From: Hannah Riddle on behalf of Planning.Responses
Sent: 26 April 2022 16:20
To: Planning Scanning
Subject: FW: Planning Re-Consultation on: Y/32/22/DOC

Engineers Comments Regarding Condition 8

Application No: Y/32/22/DOC
Registered: 8th March 2022
Site Address: 10 Acre Field Grevatts Lane West Yapton Bognor
Grid Reference: 498000 101780
Category: Discharge of Condi

Description of Works: Approval of details reserved by condition imposed under ref W/4000394 (Y/102/18/PL) relating to Condition Nos 8 - surface water drainage and 10 - maintenance & management of surface water drainage system.

Project No.	Originator	Volume	Lvl/Loc	Type	Role	Number	Rev
13591	CRH	ZZ	XX	DR	C	5200	P3

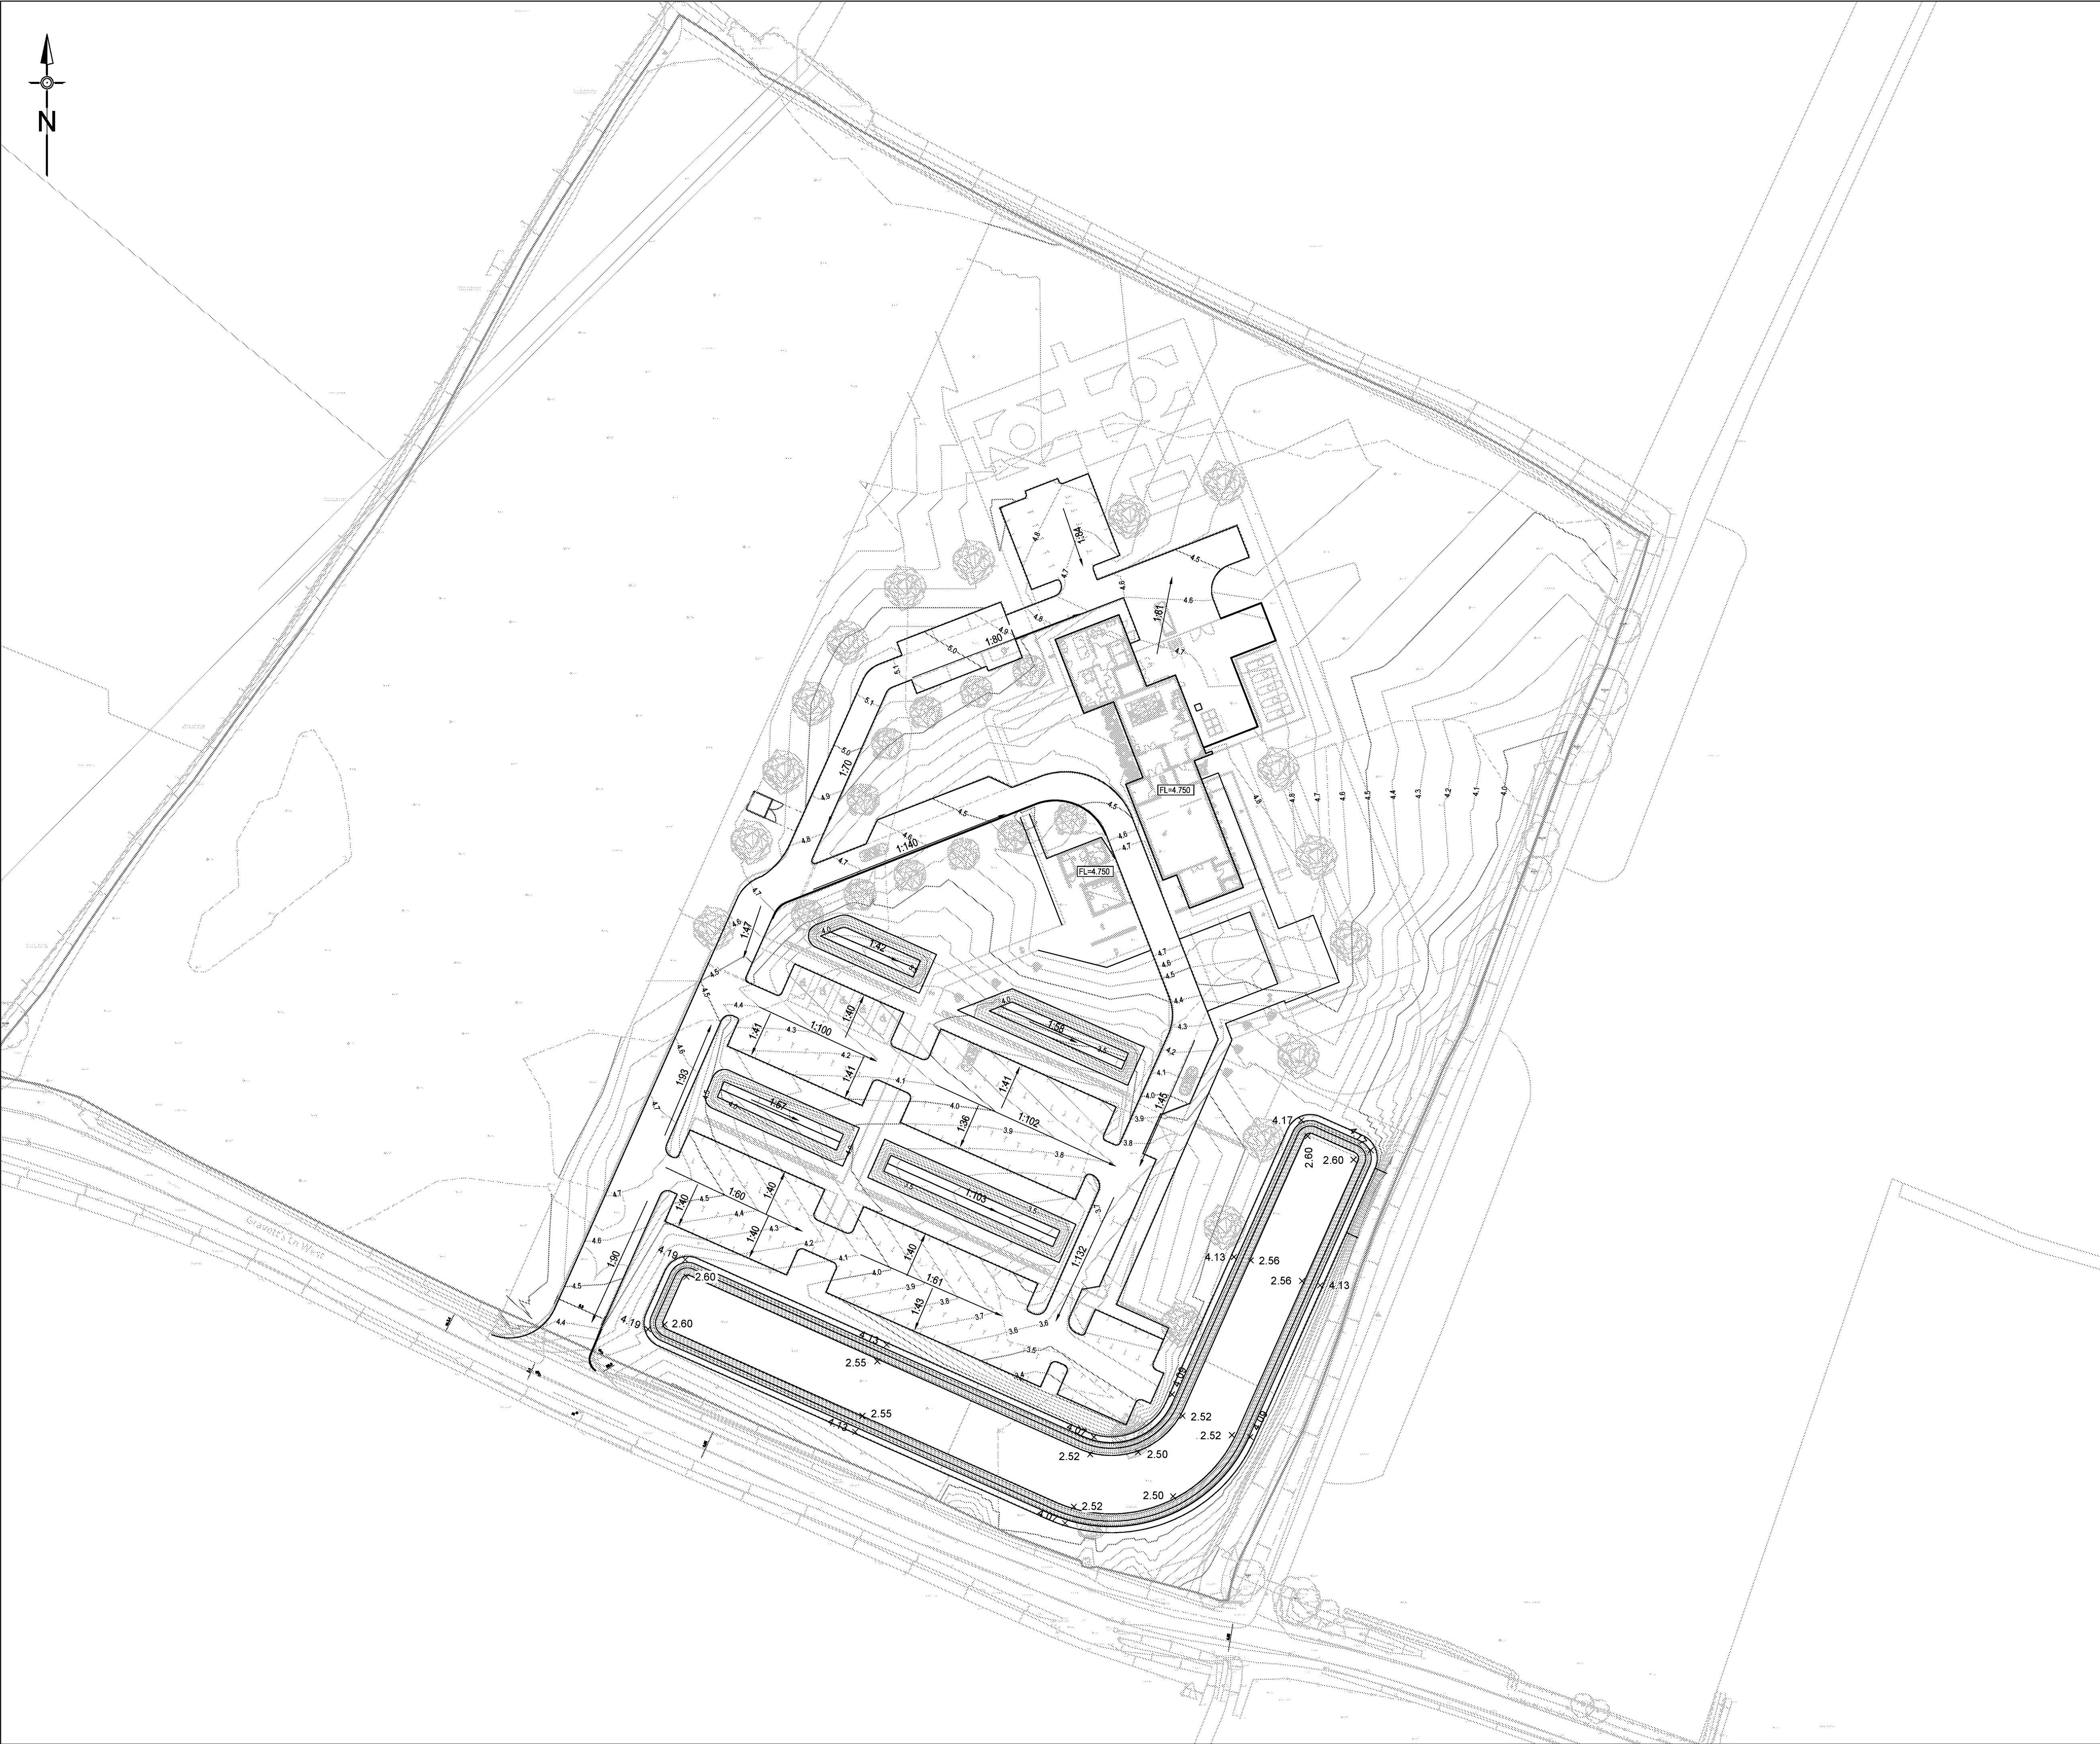
6. Please label finish and formation level of permeable paving. Permeable pavement details have been

previously provided on detail drawing 13591-CRH-XX-XX-DR-C-5350 Revision P2. This includes depths of proposed pavement build-up. The proposed surface levels can be obtained from levels plan 13591-CRH-XX-XX-DR-C-5200 Revision P3 and sub base levels inferred (Minor updates to Revision P3 enclosed for completeness). *Finish and formation levels of permeable paving must be detailed, thank you for providing a finished levels plan, please provide formation levels on layout plan, this is required to evidence adequacy of proposed connections from permeable paving. And to ensure correct construction. Formation levels of porous sub base of permeable paving have been added in green text to drawings DR-5050 and 5051 as requested. Formation levels do not match modelled invert levels or slopes. Please label invert levels of fin drains.*
